Mr Tom Harley
Chief Executive Officer
SYDNEY SWANS LIMITED
PO Box 173
Paddington New South Wales 2021

16/09/2019

**Adaptive reuse of the Royal Hall of Industries (SSD-9726)
Request for Additional Information**

Trees for Removal - 4
Trees to be Retained and Protected - 56
Proposed Trees on Ground Floor - 23

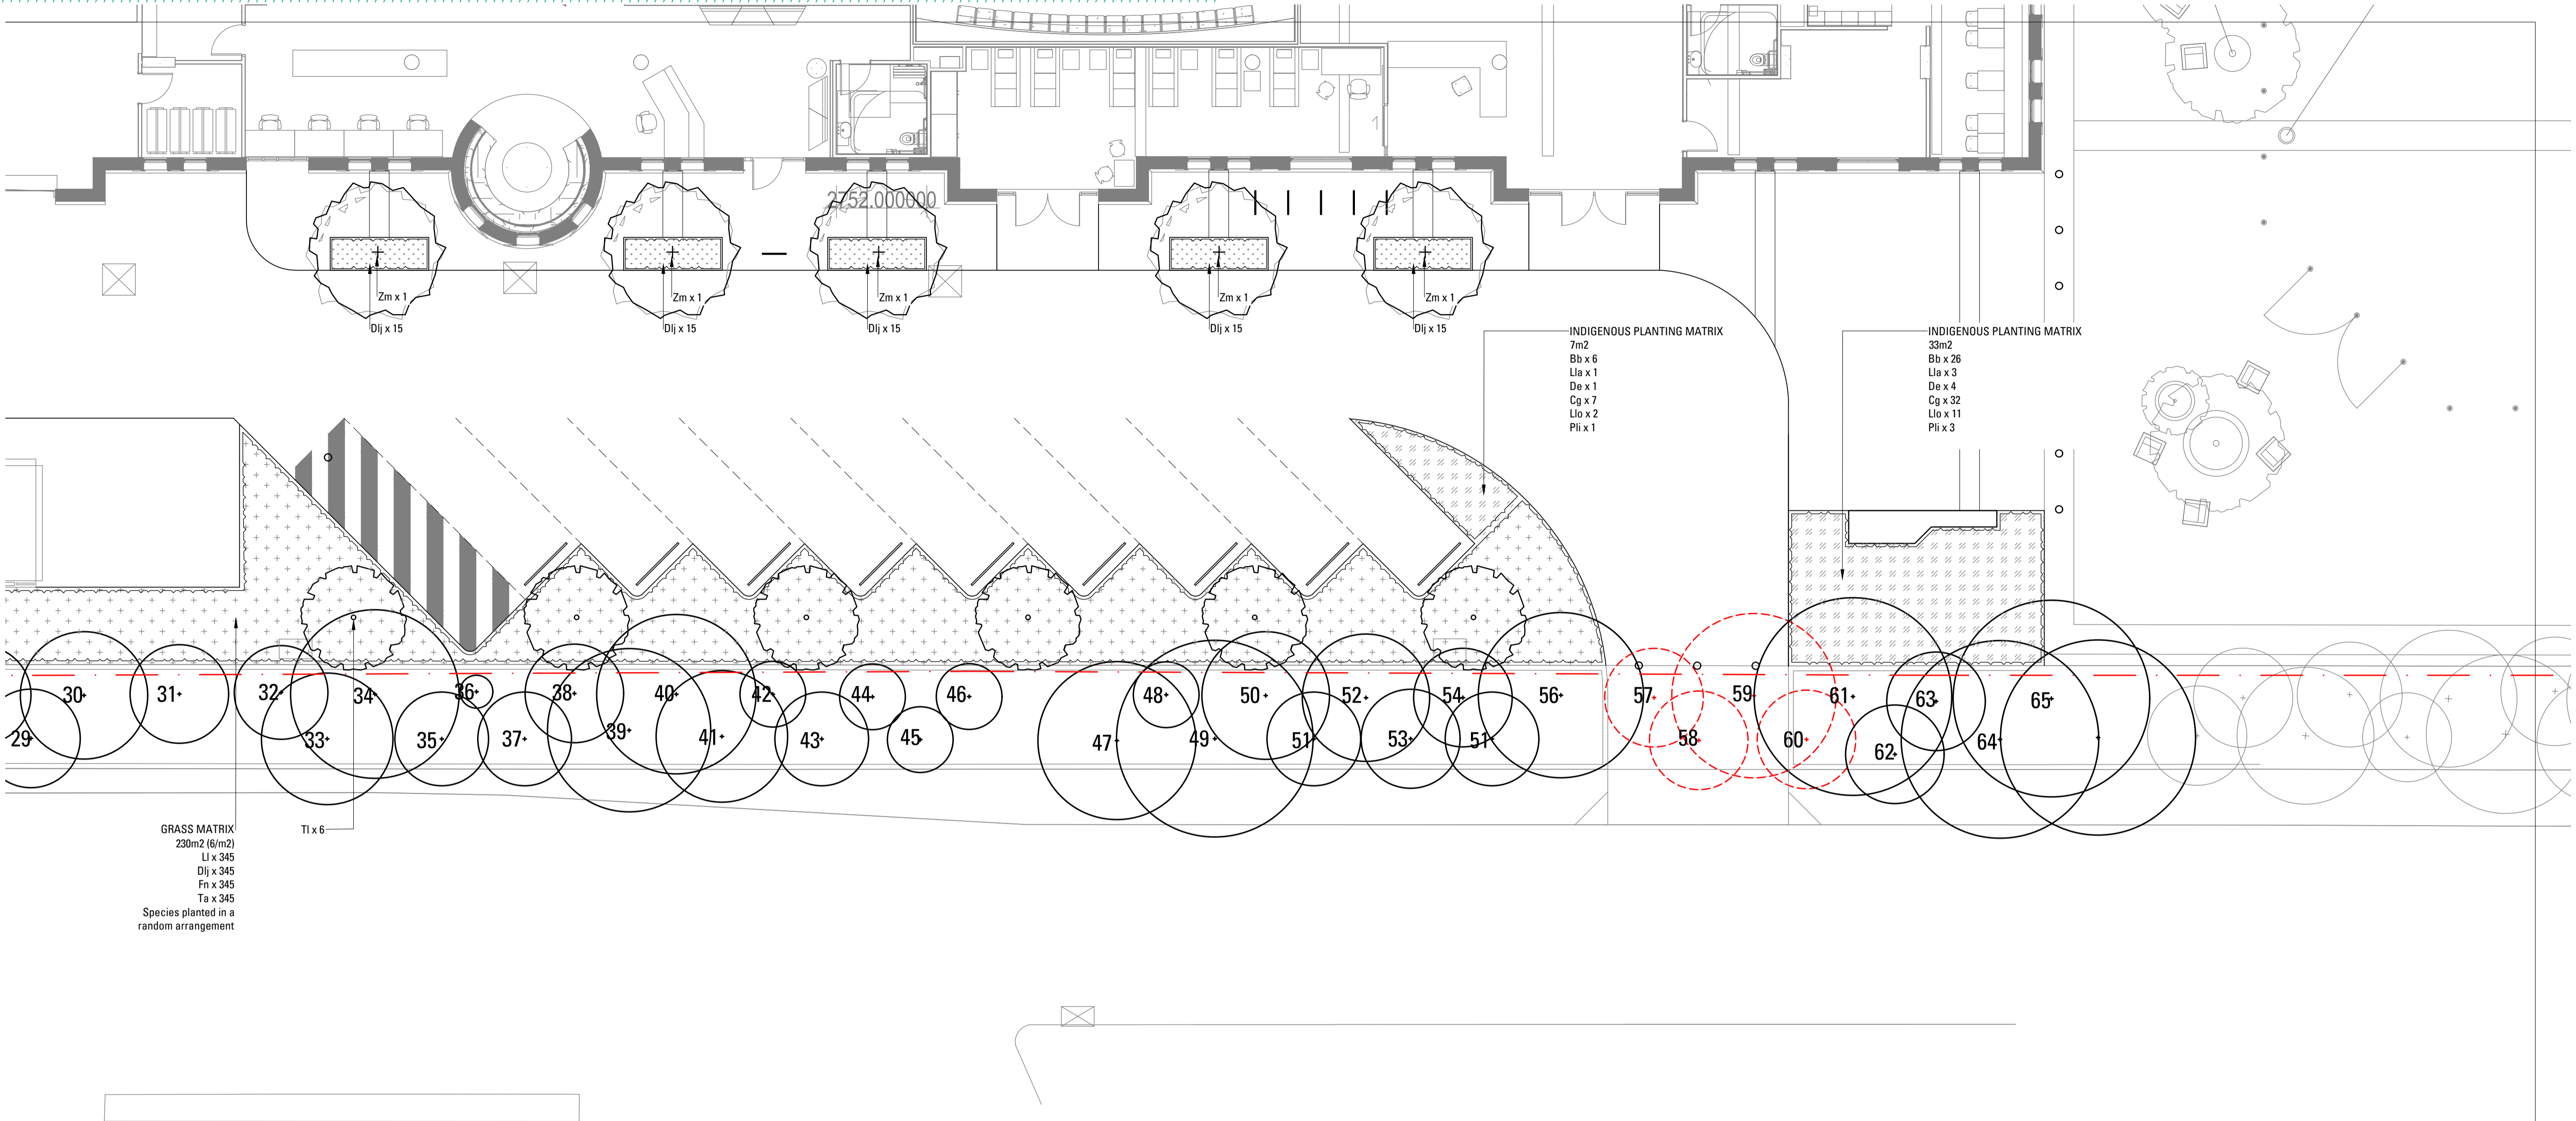
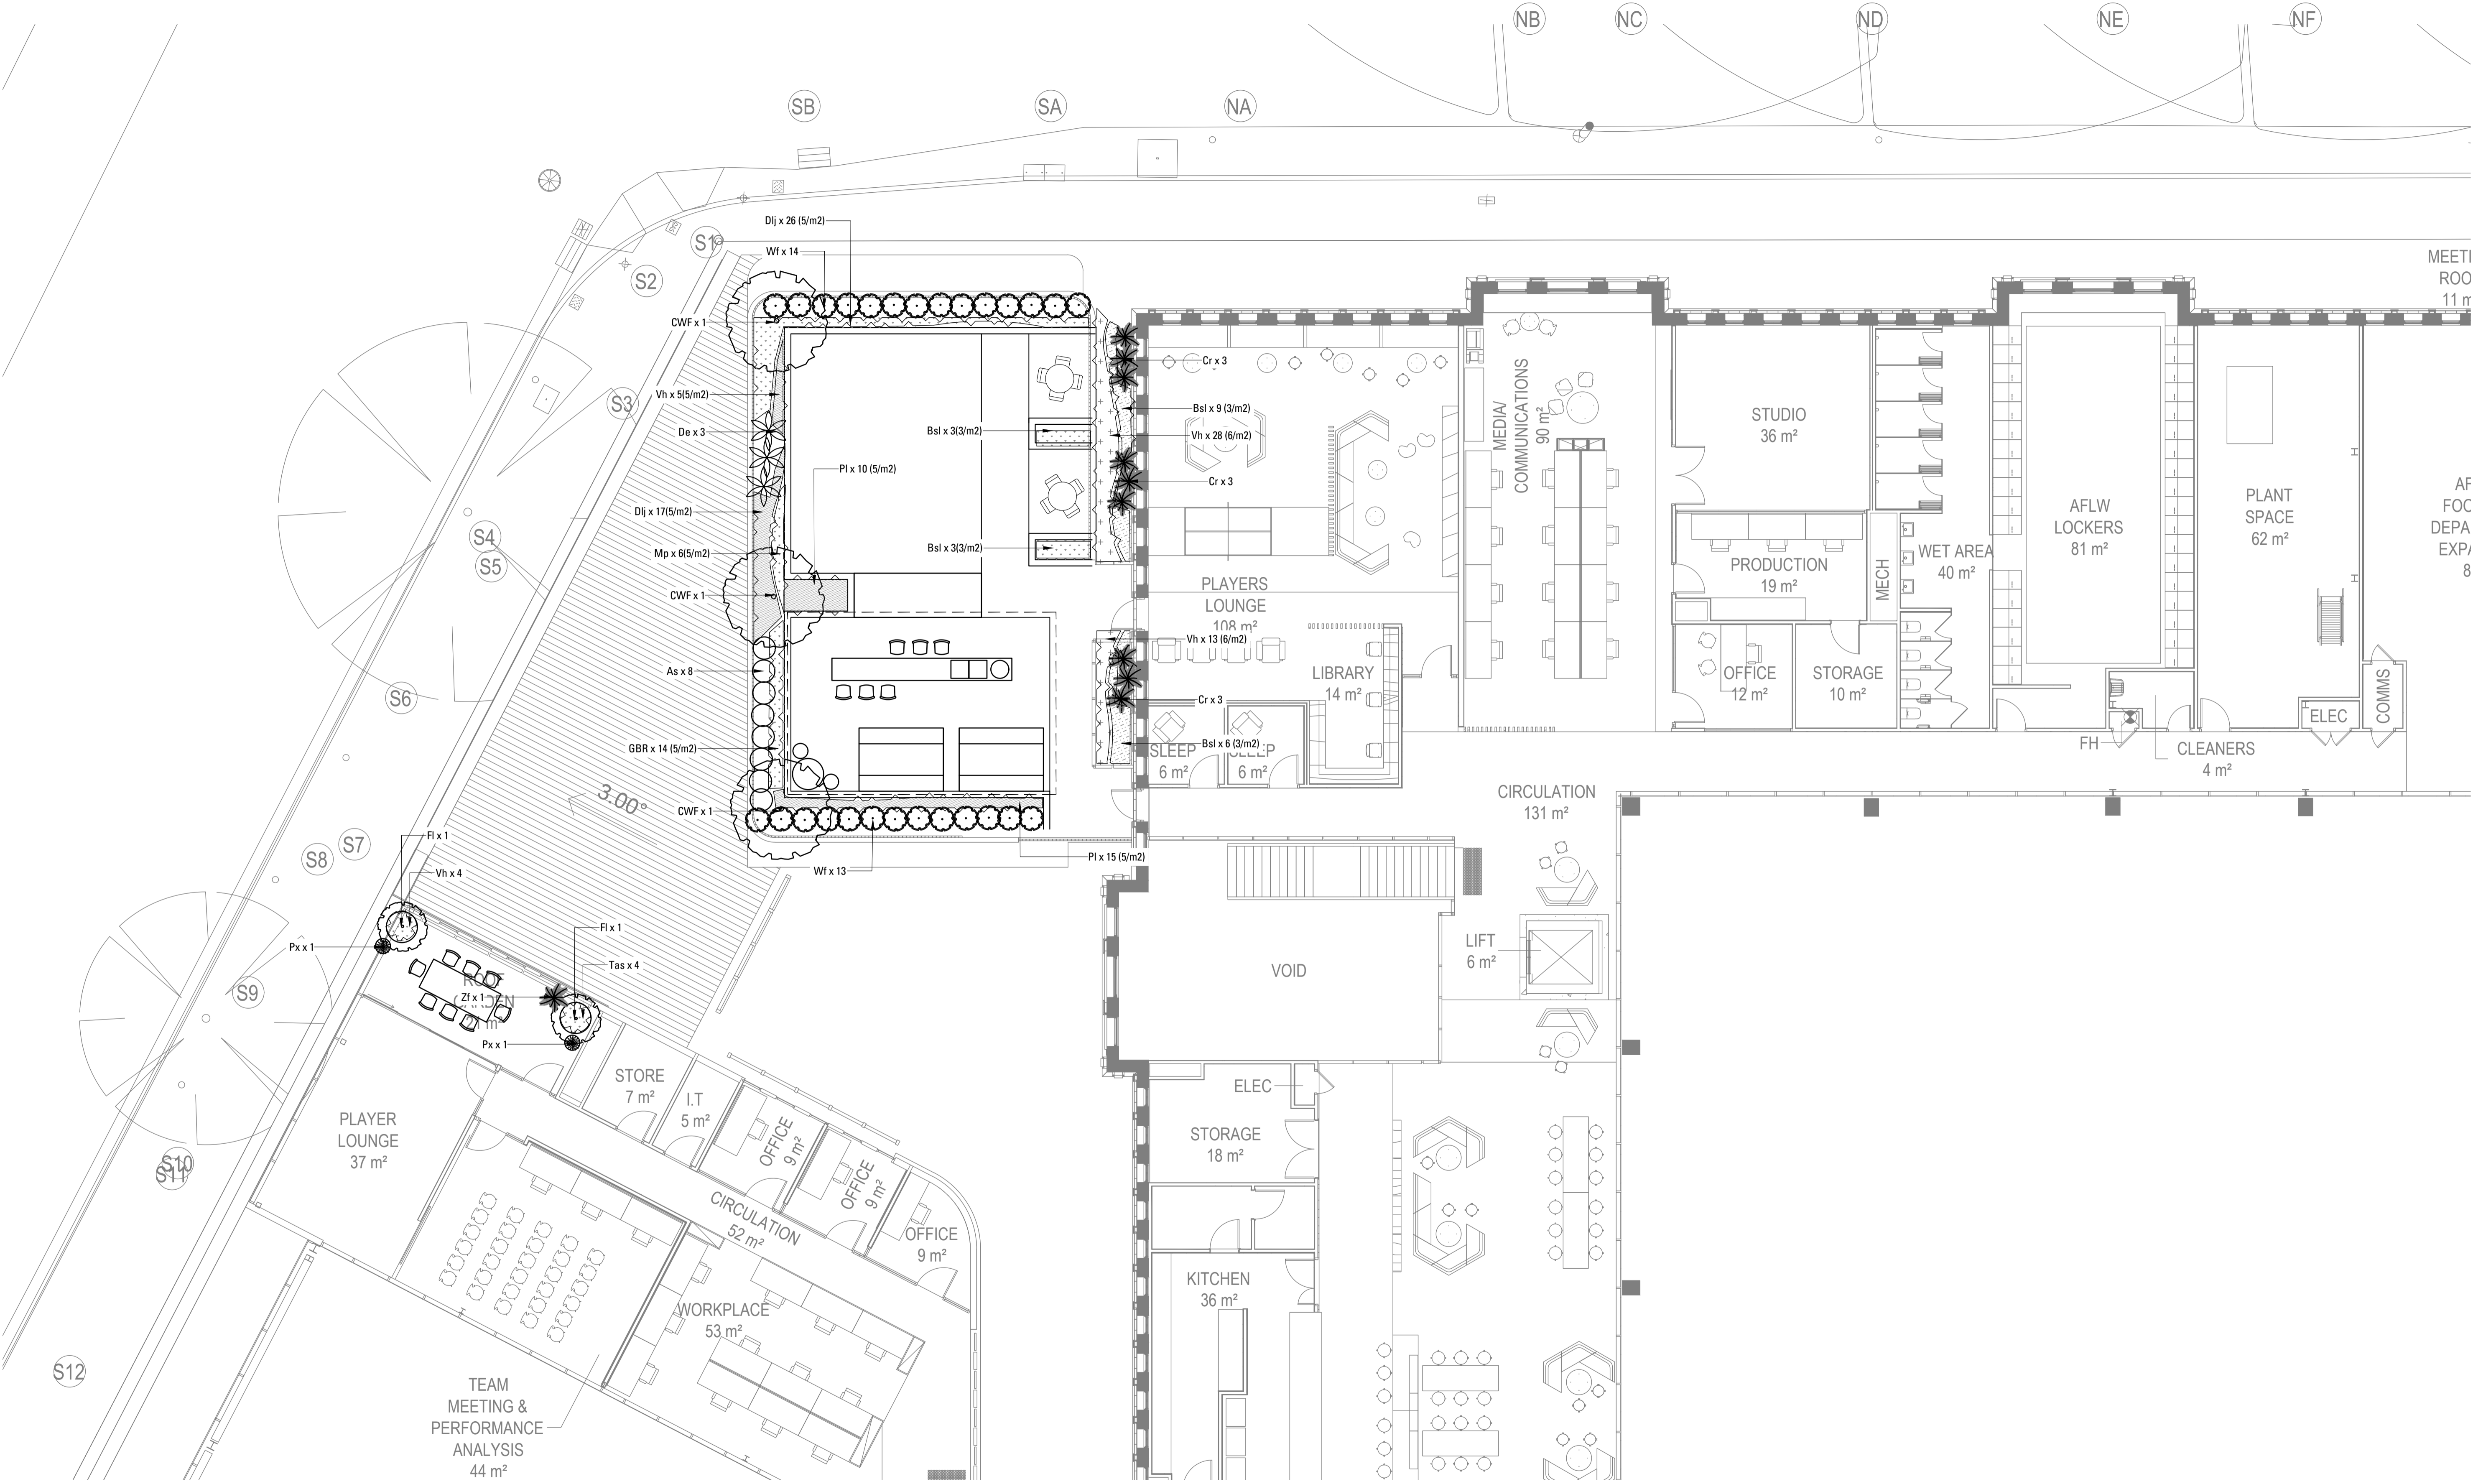
- The EIS and Arboricultural Report indicate the removal of seven trees at the site, however the landscaping plan titled "Soft works – Ground floor" indicates removal of six trees. Please provide an updated tree removal plan clearly annotating trees which are proposed to be removed.
- Consider options to maximise tree retention on site, particularly trees 58 and 59 as noted in Council's submission.
- Clarify the impact (and mitigation measures if required) to any trees adjacent to the trees proposed to be removed.
- Demonstrate how the proposal aligns with the objectives of the Eastern City District Plan to increase urban tree canopy cover, including trees over 15 metres in height at maturity.
